CITY OF ALBUQUERQUE

March 15, 2018

Re: Yale Business Center
1200 Yale Blvd. SE
Traffic Circulation Layout
Architect's Stamp **03-13-18** (L16-D040)

Based upon the information provided in your submittal received 03-13-18, the above referenced plan cannot be approved for Building Permit until the following comments are addressed:

SITE PLAN

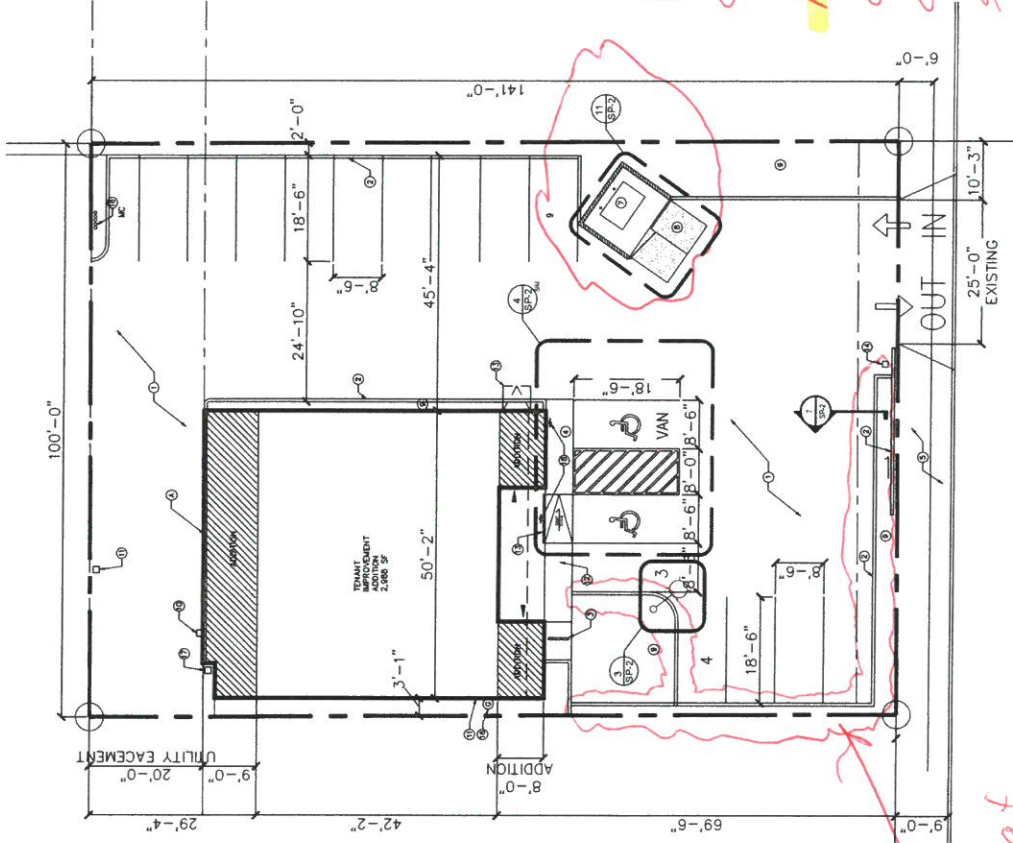
1. Please show a vicinity map showing the location of the development in relation to streets and well known landmarks.
2. List the number of parking spaces required by the zoning code as well as the proposed number of parking spaces including bicycle and motorcycle parking.

3. The ADA accessible parking sign must have the required language per 66-7-352.4C NMSA 1978 **"Violators Are Subject to a Fine and/or Towing."** Please call out detail and location of HC signs.

4. Motorcycle parking spaces shall be designated by its own conspicuously posted upright sign, either free-standing or wall mounted per the zoning code.

5. Per the zoning code, a 6 ft. wide ADA accessible pedestrian pathway is required from the public sidewalk to the building entrances. Please clearly show this pathway and provide details.

6. Please specify the City Standard Drawing Number when applicable.
7. Unused curb cuts must be replaced with sidewalk and curb & gutter. A build note must be provided referring to the appropriate City Standard drawing.
